DRB CASE ACTION LOG - BLUE SHEET

Project #: 1003532

Project Name: NORTH ALBUQUERQUE ACRES Unit(s) 3

RE: PROPOSED DENTAL OFFICE DEVELOPMENT AT 7300 HOLLY AVE. NE, ALBUQUERQUE
CASE NO. 1003532

date: 2-28-13
sheet: C100

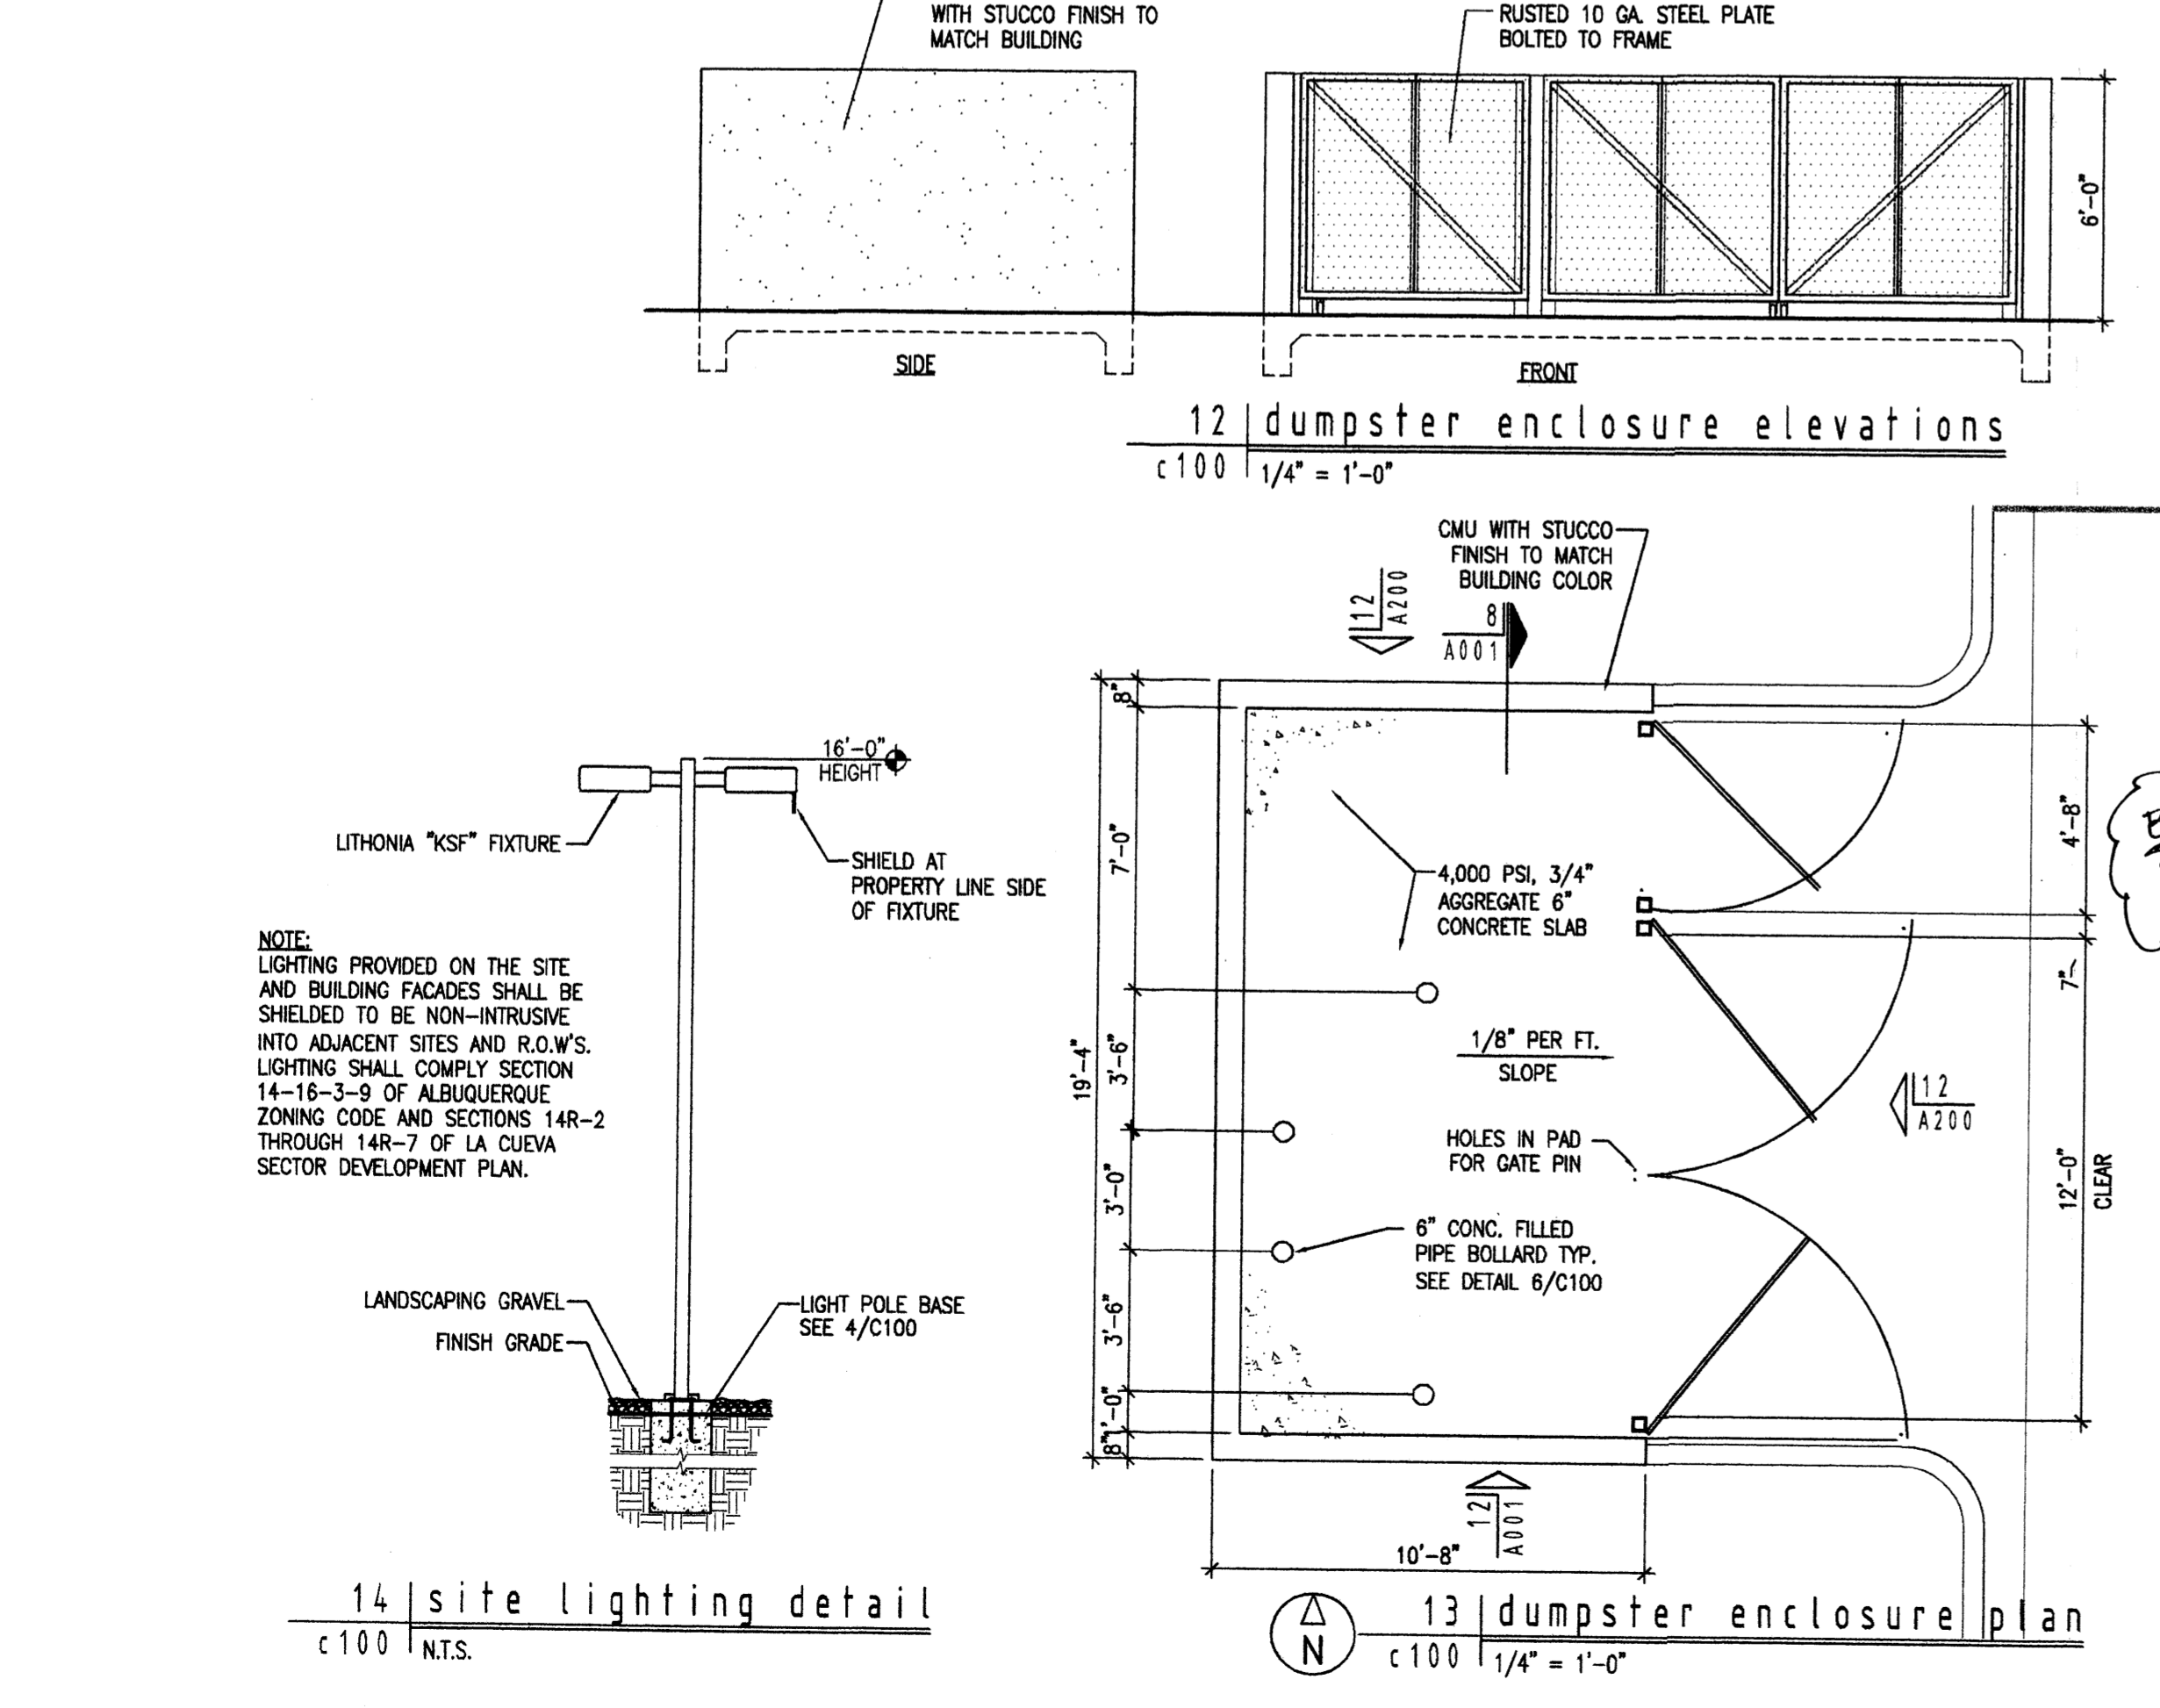
PLANNING (Last to sign): delete the word "Front"
provide exhibit for R-OW

SLAGLE/HERR ARCH. agent(s) for ROSS HOHR request(s) the above action(s) for all or a portion of Lot(s) 14, Block(s) 10, Tract(s) 2, **NORTH ALBUQUERQUE ACRES Unit(s) 3**, zoned SU-2/MIXED USE, located on HOLLY BETWEEN LOUISIANA AND WYOMING containing approximately .886 acre(s). (C-19) **THE SITE DEVELOPMENT PLAN FOR BUILDING PERMIT WAS APPROVED WITH FINAL SIGN-OFF DELEGATED TO CITY ENGINEER FOR REVISIONS TO DRAINAGE PLAN AND TO PLANNING FOR DIMENSIONAL EXHIBIT AND REMOVAL OF THE WORD "FRONT" FROM THE SETBACK NOTE.**
2. **Project# 1004976**
13DRB-70542 EPC APPROVED SDP
FOR BUILD PERMIT
